Comments on the Applicant's D5 Submissions

This document sets out the comments on the Applicant's Deadline 5 (D5) submissions by Cambridgeshire County Council (**CCC**). The tables below set out the document in question that the Council is commenting on, together with the relevant paragraph or reference number.

6.2 Appendix 13C Framework Construction Traffic Management Plan and Travel Plan (Tracked) - Rev: 04 [REP5-015] and all Appendices (A to G) [REP5-016 to REP5-042]

ACM-60589004-AMR-DR-0040

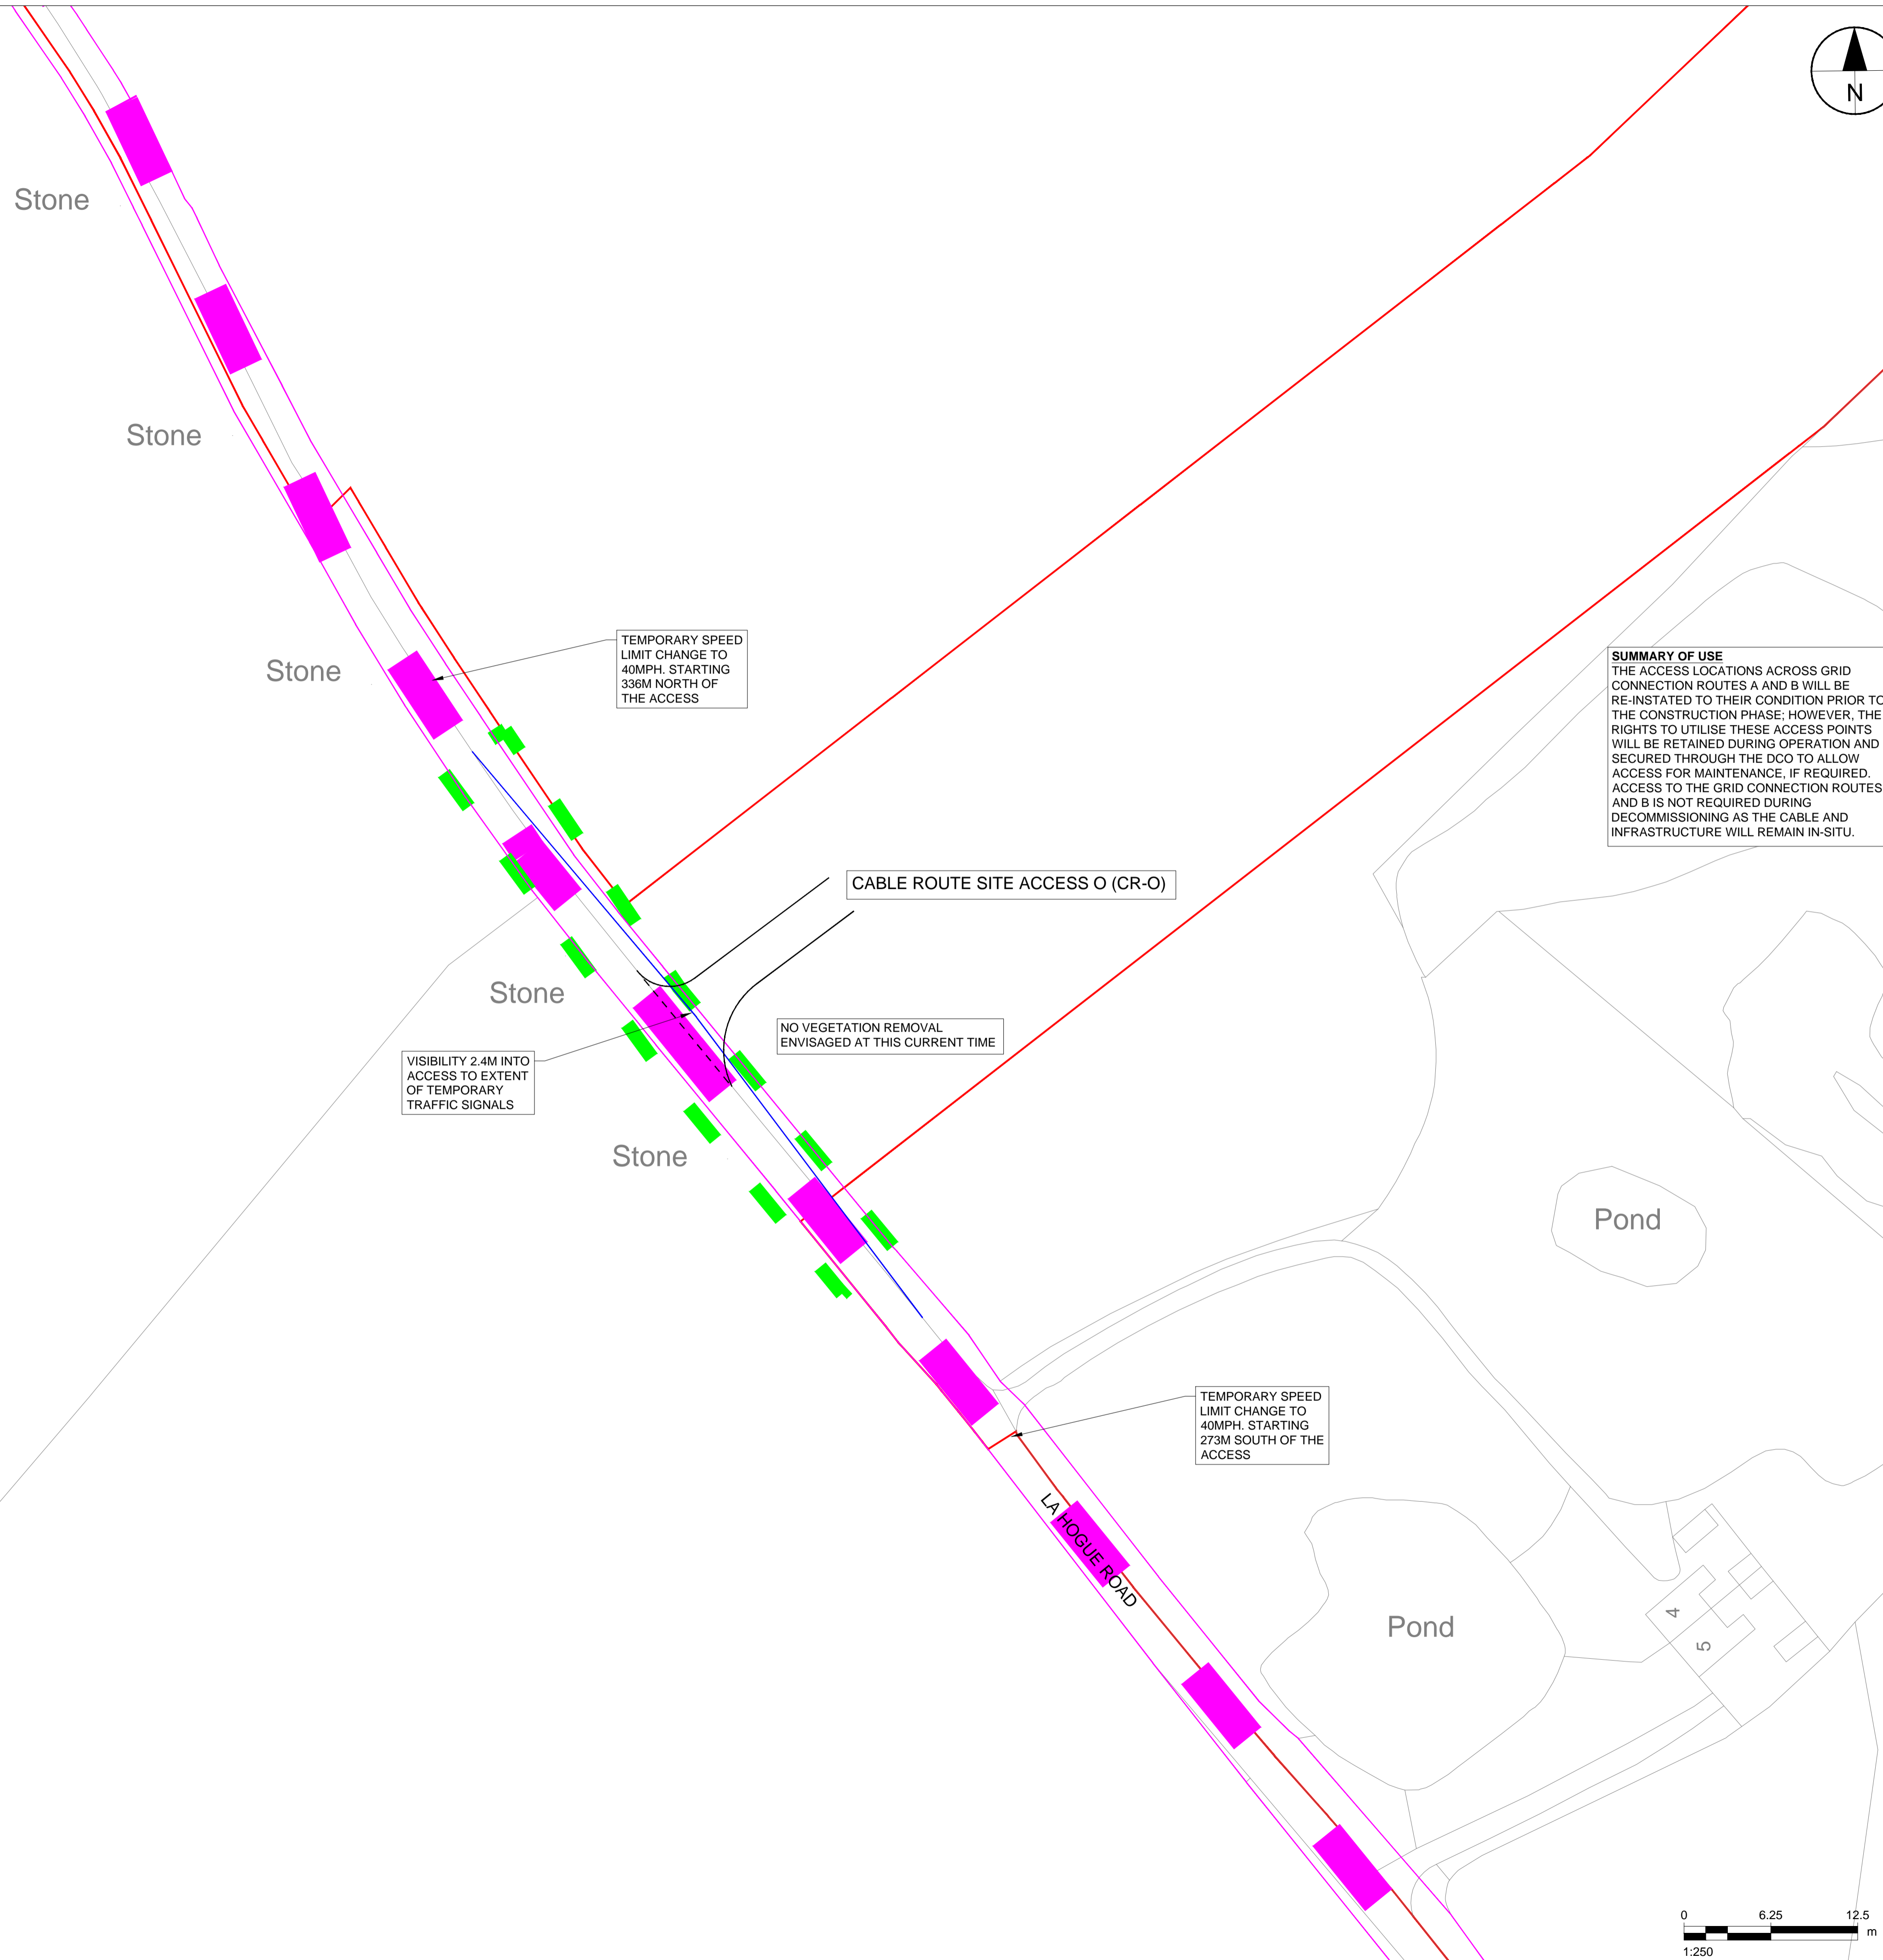
Plan ACM-60589004-AMR-DR-0039/-0040	Cable Route Access P. B1085.	<p>The proposal is to utilise an unmade field access, with improvements proposed, including 14m radius to the east and 6m radii to the west.</p> <p>The swept path detail shown does not demonstrate the ability for two vehicles to pass, and while movement will be managed by traffic signals during the construction phase, it is unclear how the access will be used during the operational phase, or how such conflict will then be managed. It is therefore unclear whether safe access is provided.</p> <p>No visibility splays have been detailed to demonstrate that visibility appropriate to the speed of the road can be achieved within the DCO or Highway boundary. The highway is bounded by a dense hedgerow to the west and trees to the east, both of which are close the road edge; It appears unlikely that suitable visibility can be achieved without significant removal of trees/hedge to allow safe uncontrolled access and it is not therefore possible to</p>

confirm that safe access can be achieved during the operational phase in the absence of traffic management.
Plan ACM-60589004-AMR-DR-0039/-0040	Cable Route Access Q. B1085.	<p>The proposal is to utilise an existing field access, with improvements proposed, including 14m radius to the east and 6m radii to the west.</p> <p>The swept path detail shown does not demonstrate the ability for two vehicles to pass, and while movement will be managed by traffic signals during the construction phase, it is unclear how the access will be used during the operational phase, or how such conflict will then be managed. It is therefore unclear whether safe access is provided.</p> <p>No visibility splays have been detailed to demonstrate that visibility appropriate to the speed of the road can be achieved within the DCO or Highway boundary. The highway is bounded by a dense hedgerow to the west and trees to the east, both of which are close the road edge, compounded further by the road to the east bending to the south; It appears unlikely that suitable visibility can be achieved without significant removal of trees/hedge to allow safe uncontrolled access and it is not therefore possible to confirm that safe access can be achieved during the operational phase in the absence of traffic management.</p>
